**Grahame Edwards - Re: Huskisson Hotel MP07\_0004 MOD 2**

Thank you for your email seeking comment on the S75W modification application for Huskisson Hotel (Mod 2).

DRAWING TITLE
PROPOSED ADDITIONS AND
ALTERATIONS :-
BASEMENT PLAN

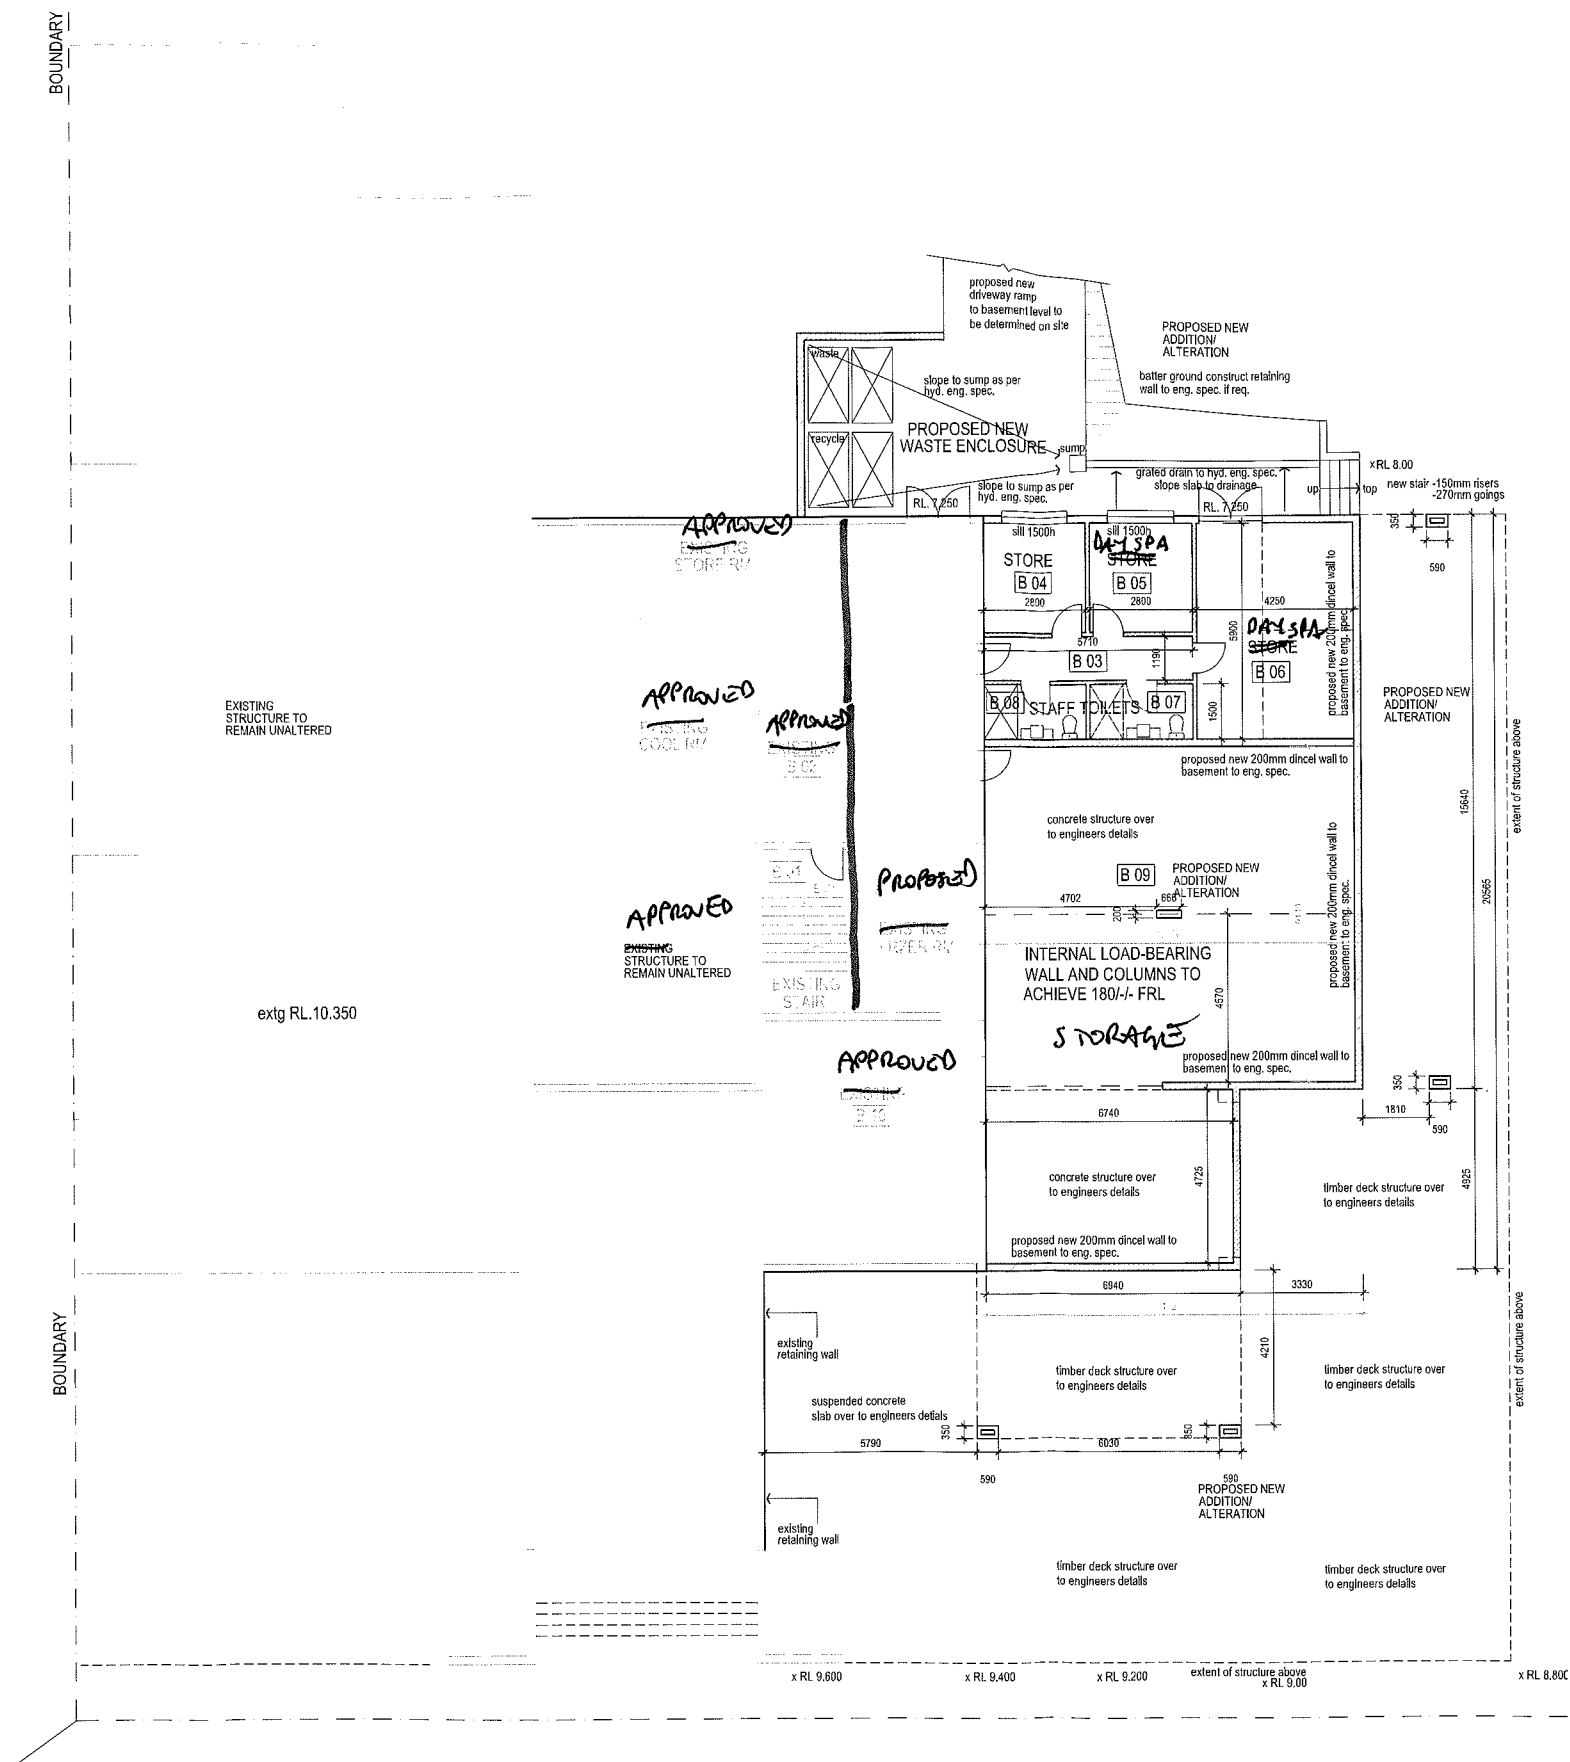
As the modification request seeks new basement area and requires excavation, the applicant needs to be advised that if the modification is likely to intercept groundwater that under the Water Management Act (WMA) 2000 all works that intercept groundwater will now require an aquifer interference approval. However, in the absence of a formal Aquifer Interference Policy, licensing is still required to be processed under the Water Act 1912. In the interim the proponent must ensure all works that intercept groundwater for monitoring, dewatering and test purposes are authorised under Part 5 of the Water Act until such time the Aquifer Interference Policy has been finalised. The NOW will determine the need for a licence once detailed information is provided.

STAGE 1: HUSKISSON HOTEL LANDSCAPE DA PLAN

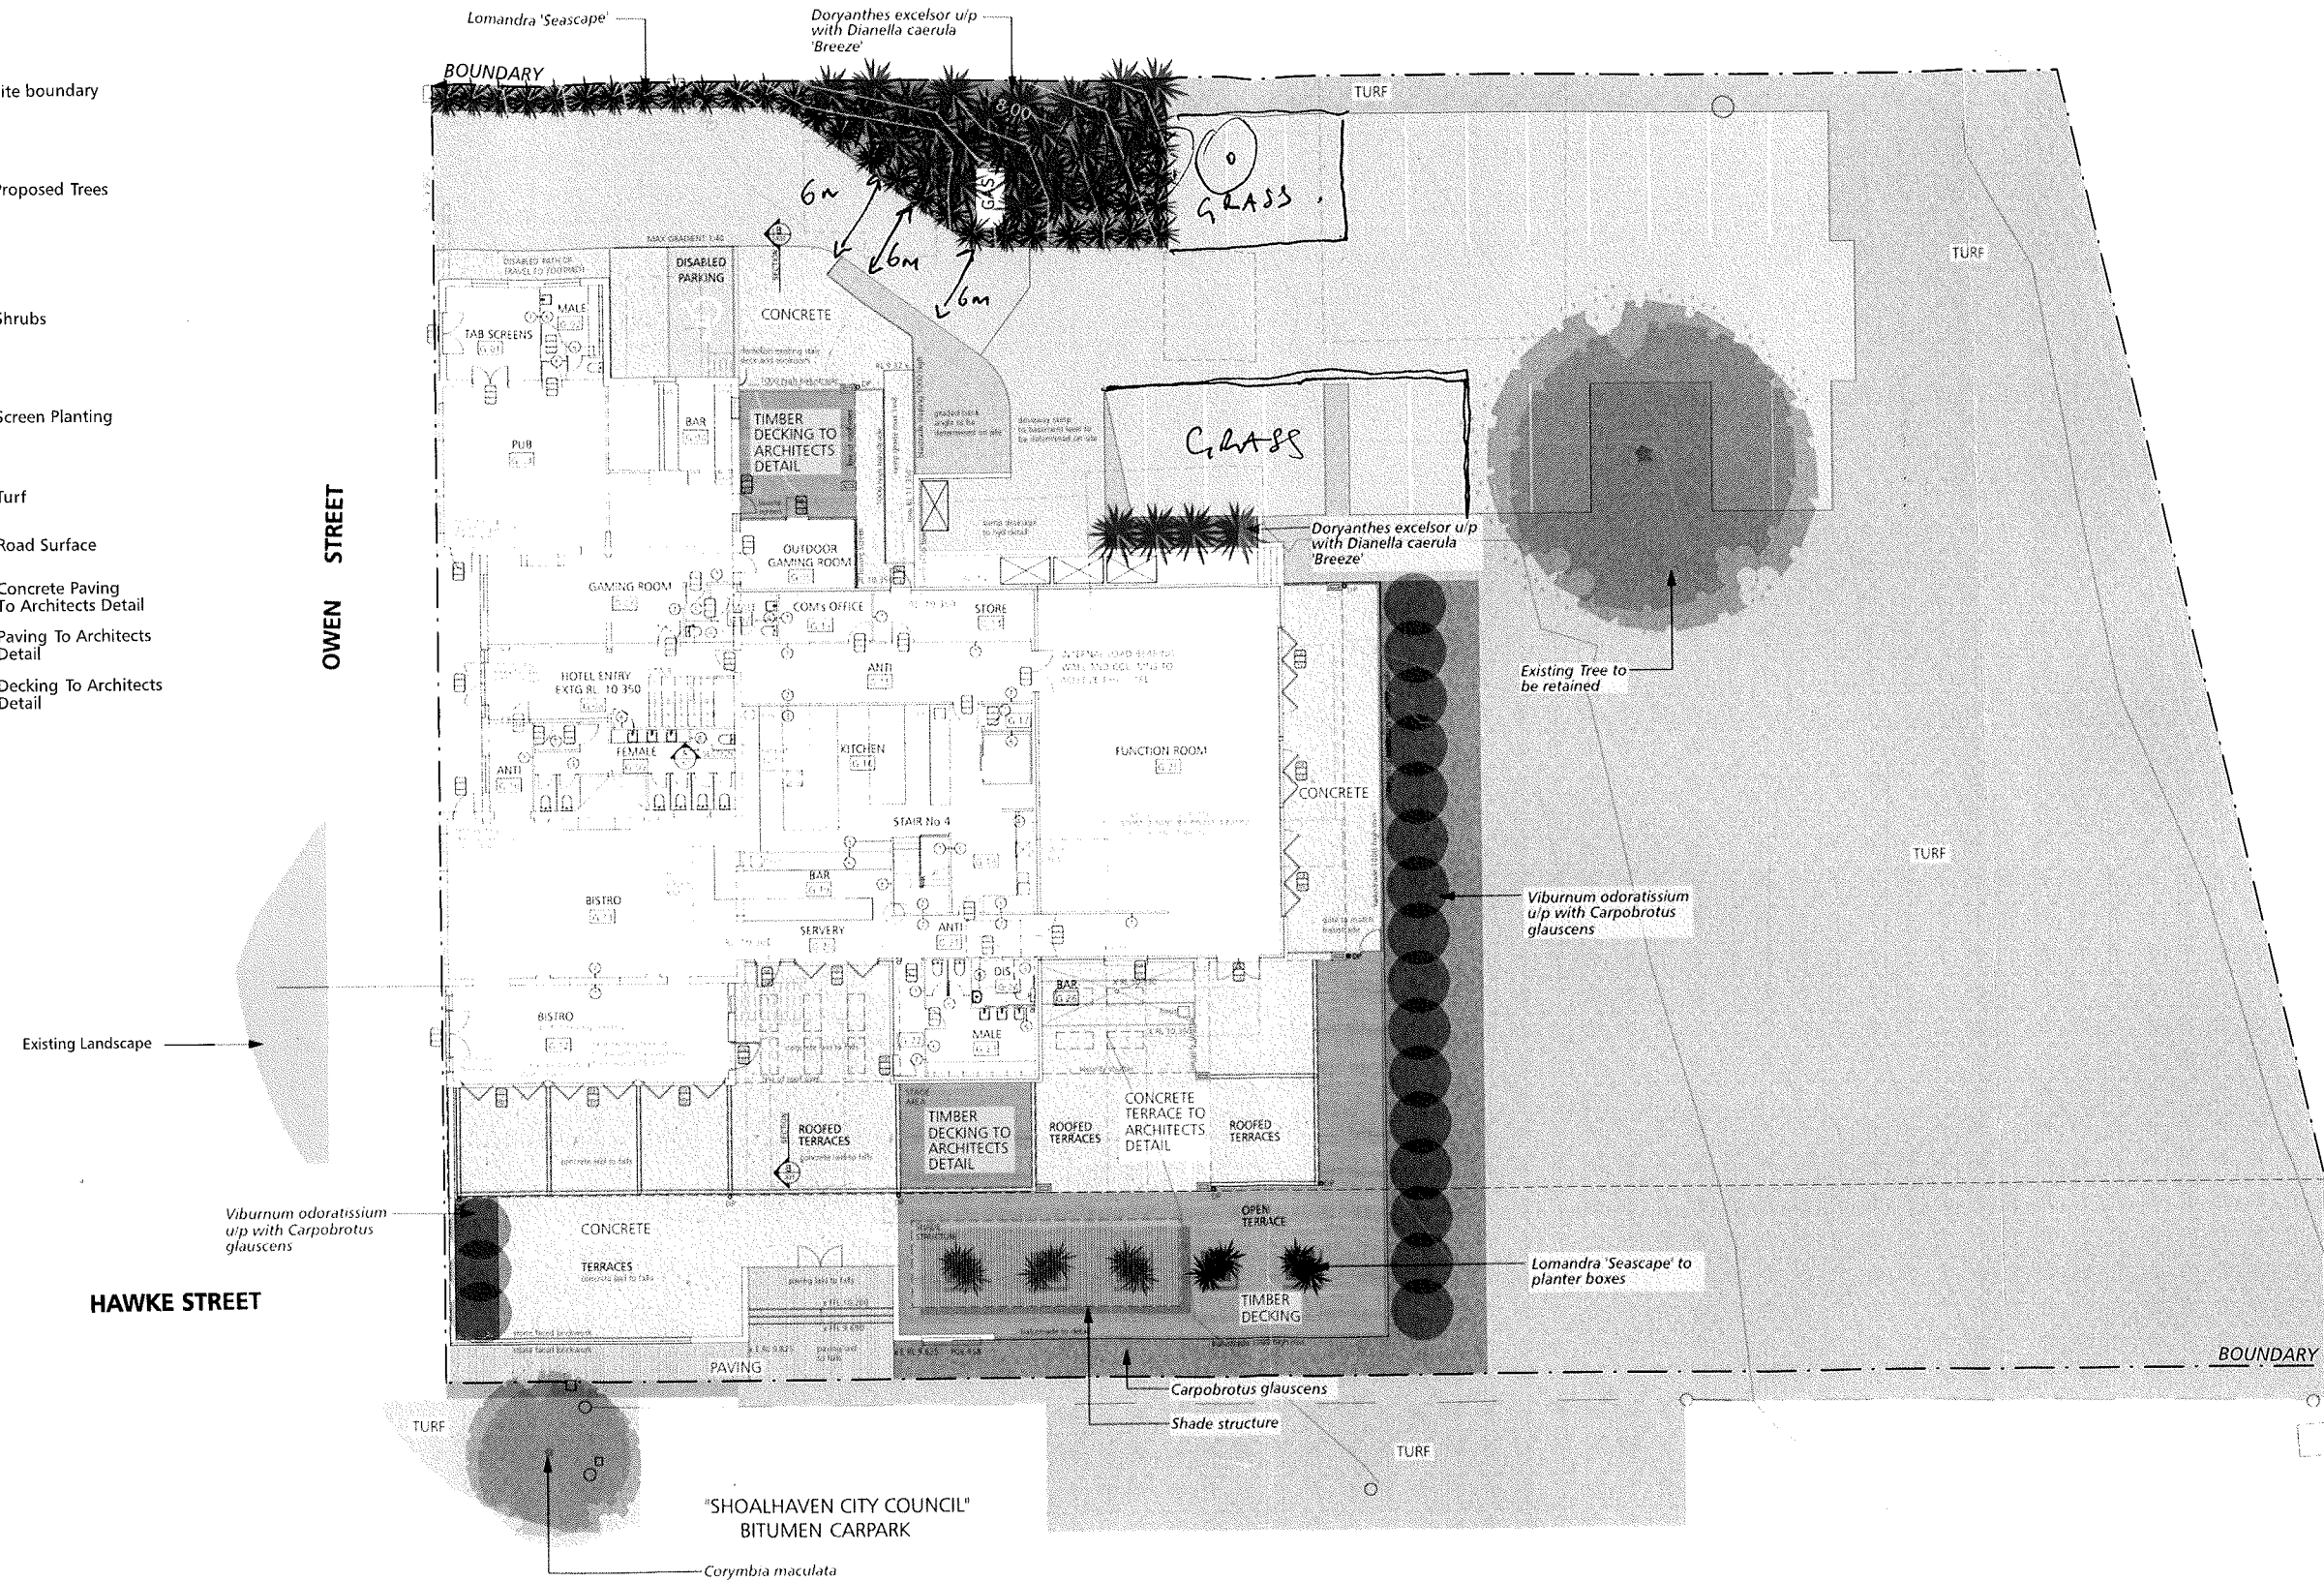
It is noted the Landscape Plan proposes to replace two areas of road surface with grass. It is recommended these areas are planted with local native plant species which are appropriate to the site rather than with grass.
